Application No: M/2/21/HH
Site Address: 45 Southdean Close Middleton-On-Sea PO22 7TH
Description of works: Two storey front extension, first floor side extension, single storey side extension, two storey side extension, conversion of roofspace to habitable use with rear dormer and installation of 4 x balconies.

Thank you for your internet representation made on 15th February 2021 which has been recorded as an objection with the comments as follows:

Revisions:

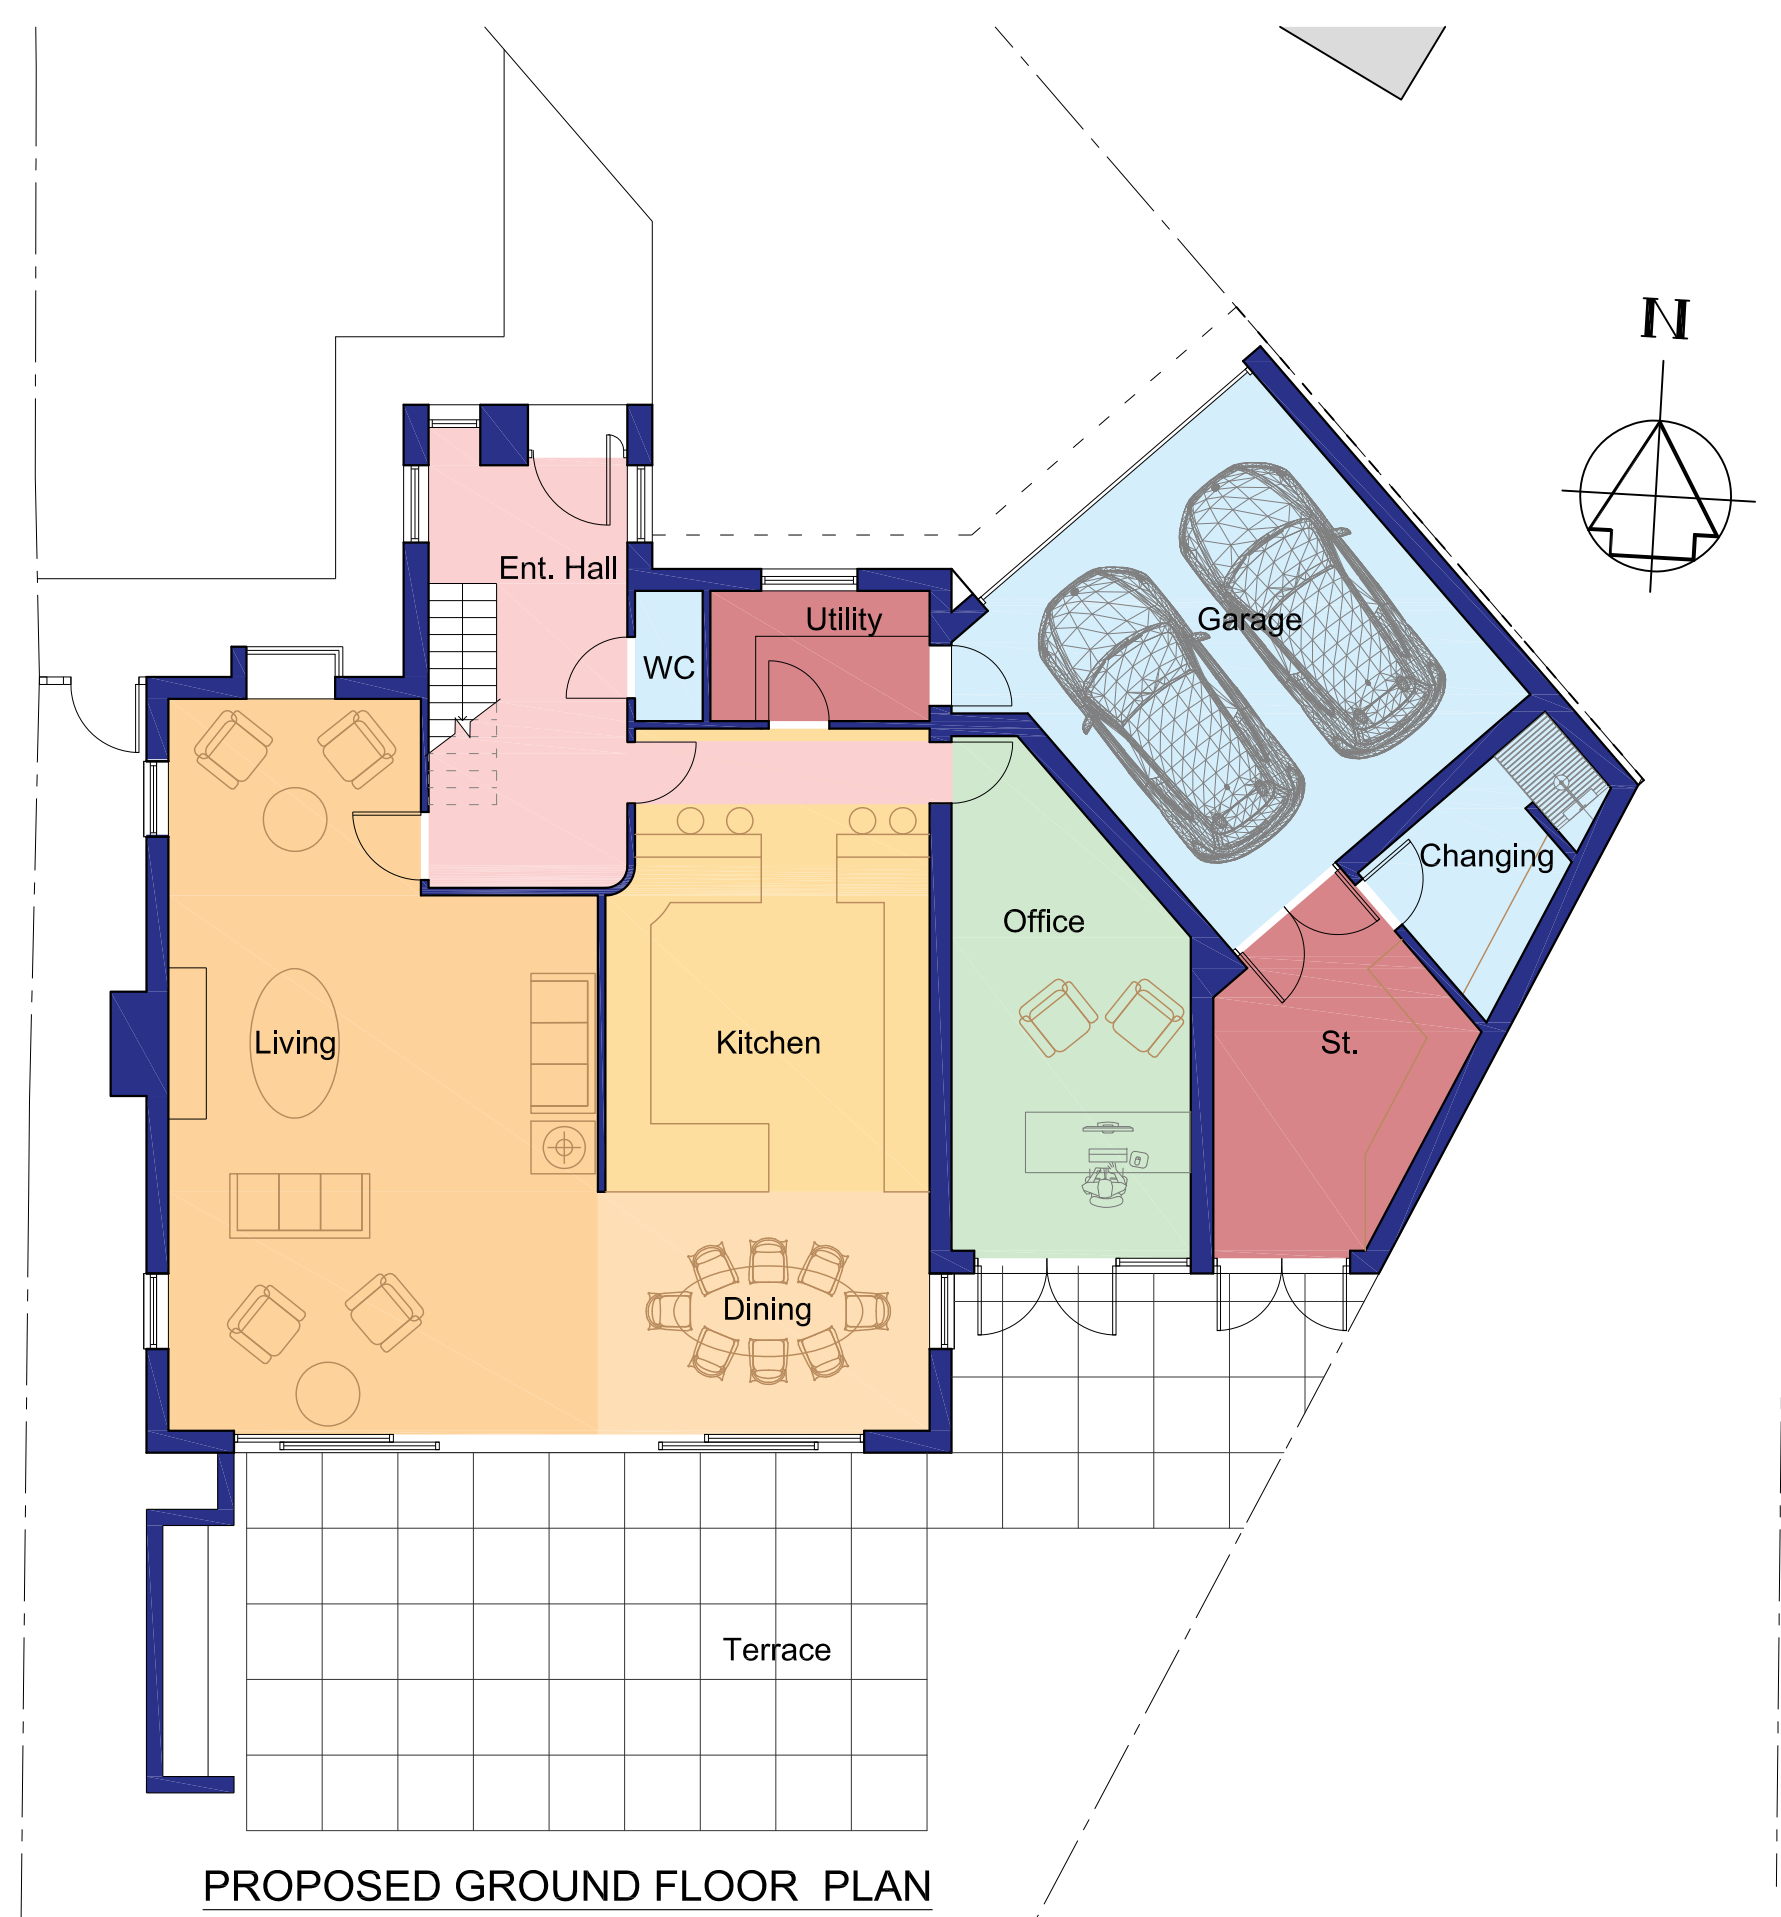
The proposed front extension is higher than the existing roof and is not in keeping with this small close. The proposed side extensions will be too close to houses on both sides of the property plus one house on the Elmer Beach estate. The conversion of the roof to include bedrooms and balconies effectively will make this 3 floors, again too large for the plot.
